**Your Ref:** OWPC23159  
**Our Ref:** FP/103/19/PL  
**Please ask for:**  
Michael Eastham

Amendment to Planning Reference Y/68/09 to replace sports pitch with a public amenity area.

Land North of Felpham Felpham

Drawing Title:
CHANGING FACILITIES BUILDING
SITE LAYOUT

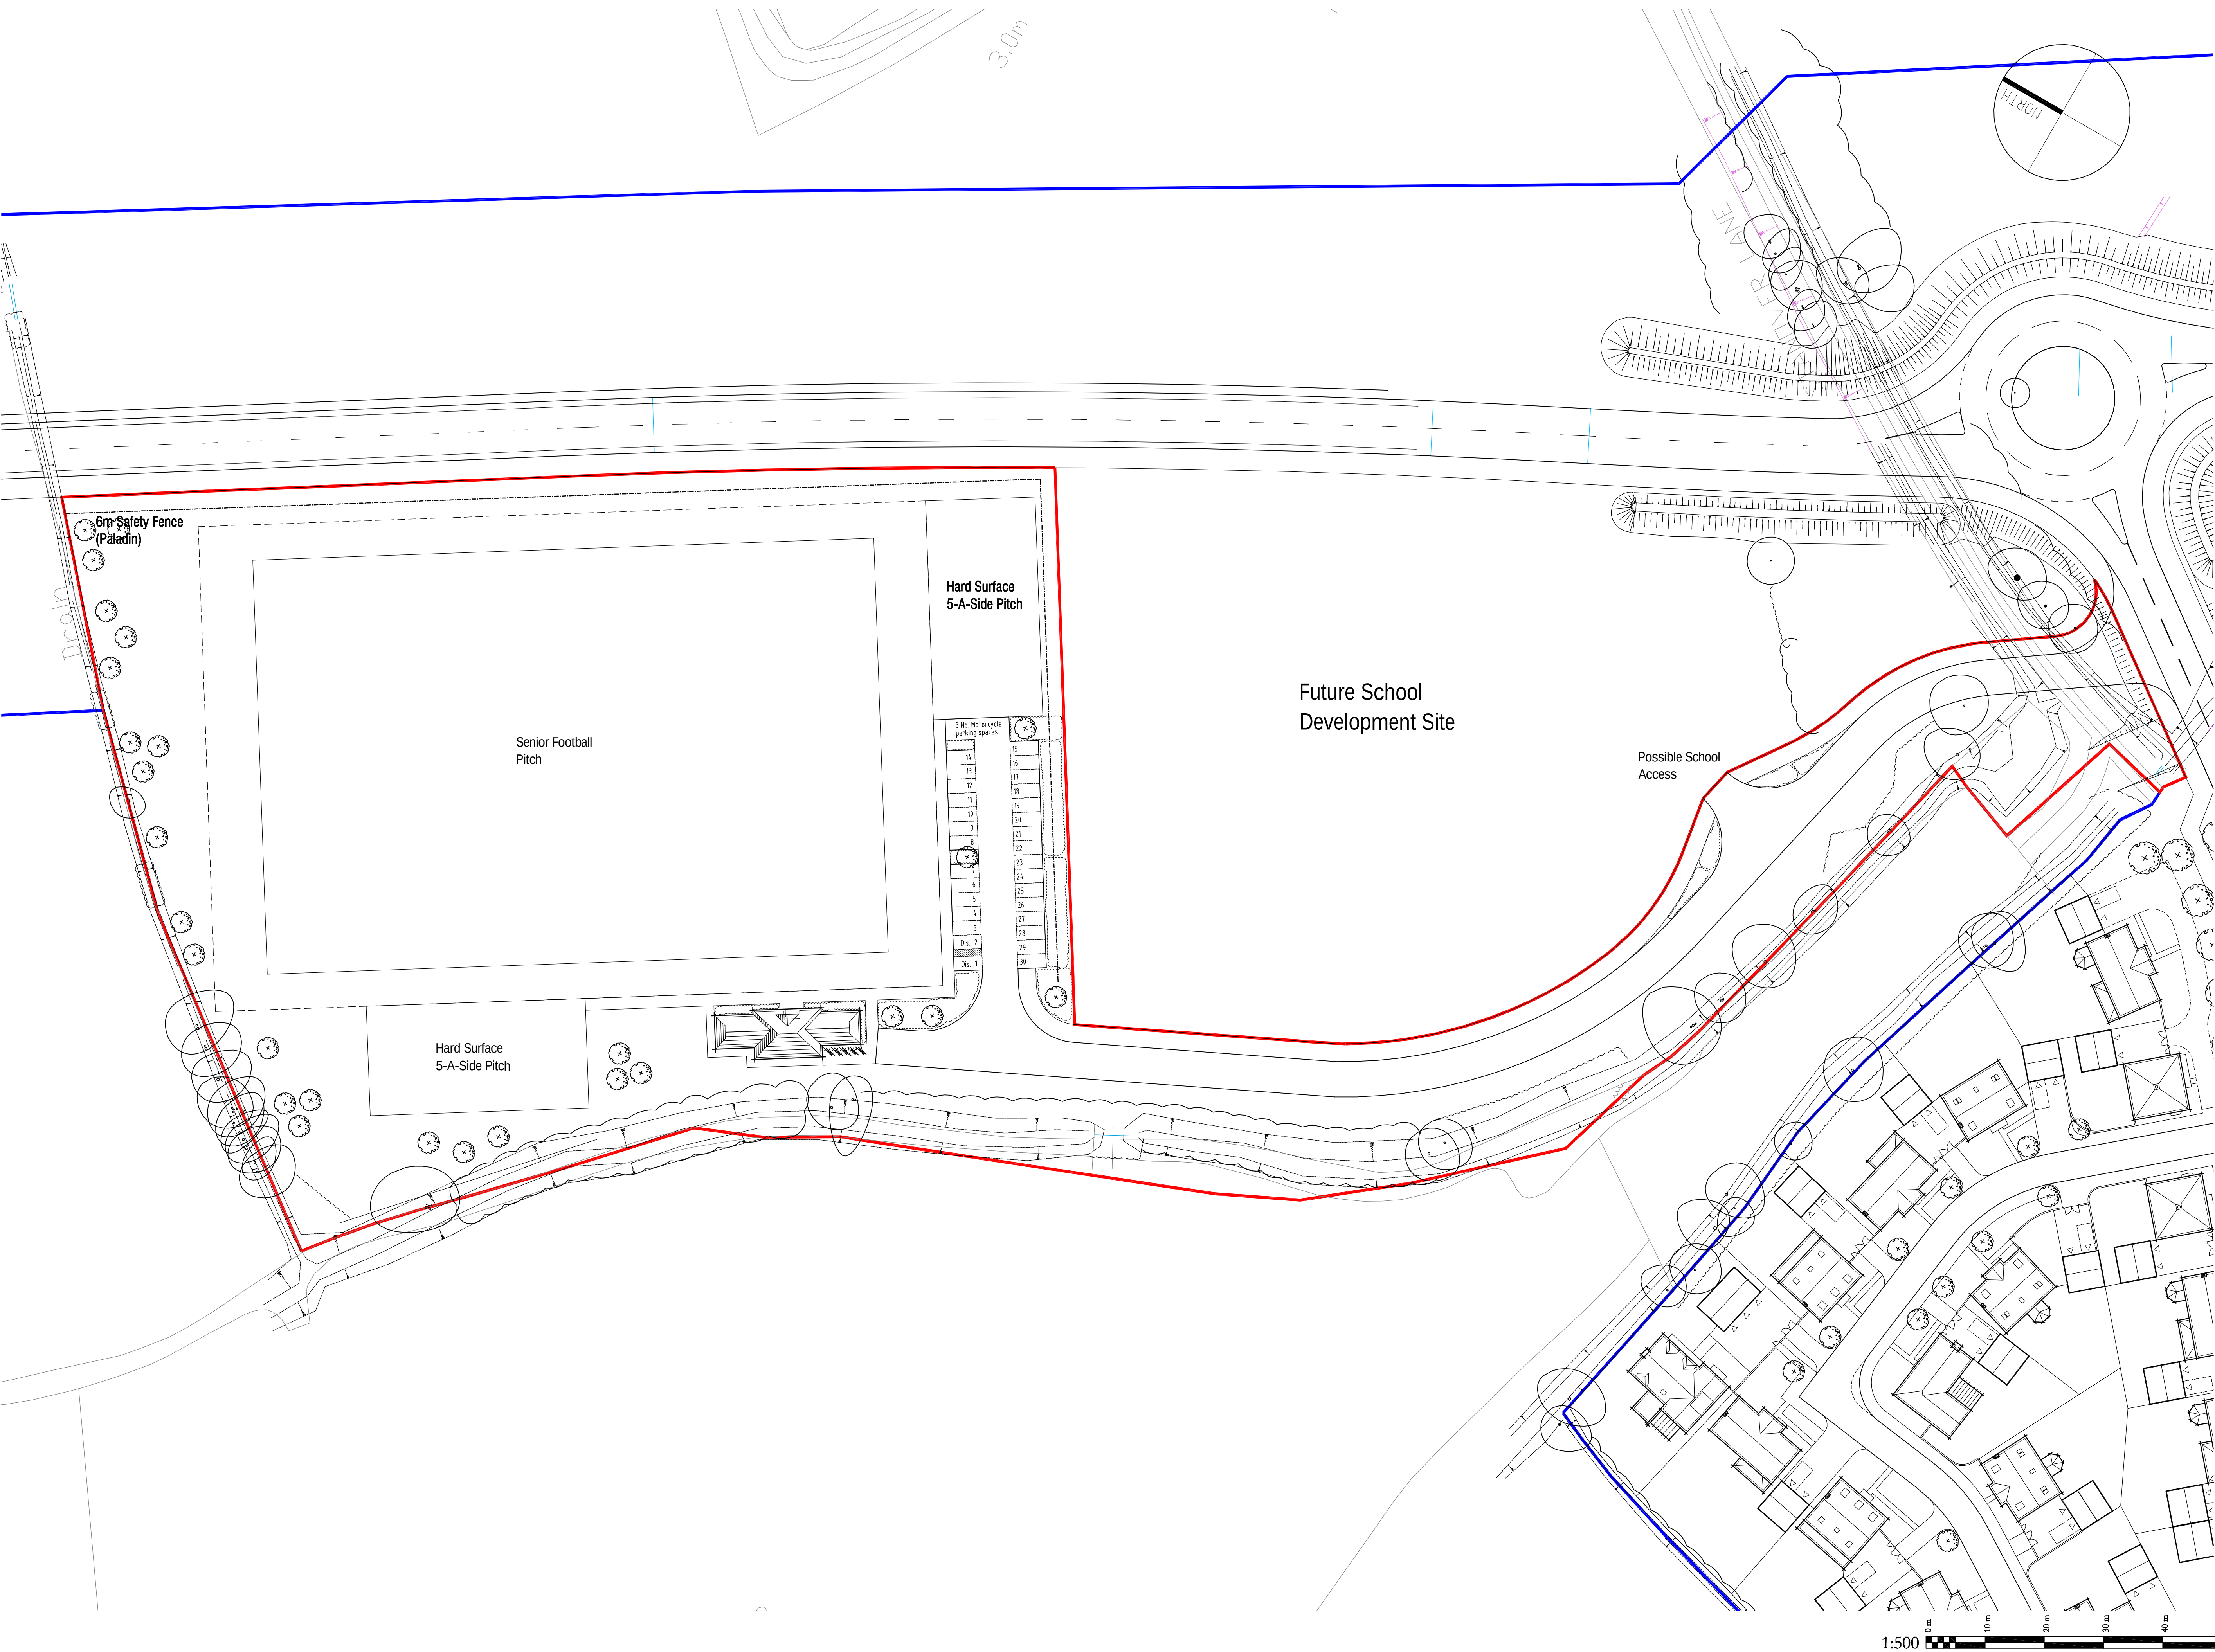
*Lack of detail and information provided on which to make a decision. In order for this to be considered the Parish Council would seek further information and clarification as follows:*

- *Insufficient detail about fencing.*
- *Insufficient detail about prevention of vehicles accessing the green space and using it as a vehicle playground at risk to pedestrian users/dog walkers etc.*
- *The need for significant and effective speed bumps/control measures to be introduced on the road in to the area to control speed.*
- *Lighting should be provided on the road to the car park and the car park itself.*

- *There is insufficient detail about how to preventing access to larger vehicles, caravans, motorhomes.*
- *This location will be a prime site for travellers so robust height limiting bars must form part of the initial access*
- *The site could also be attractive to so called "boy racers" or people using as a location to show off their vehicles so prevention measures must be in place.*
- *Any access point to the greenspace area must be protected by robust gating which prevents unauthorised access.*
- *Will the site have road access fenced off and closed during the night in keeping with some other areas in Felpham. Footpaths, cycle access to remain open.*
- *A bye law is needed making it illegal for overnight stays, including camping, caravans, motor/mobile homes, dumping of rubbish etc.*
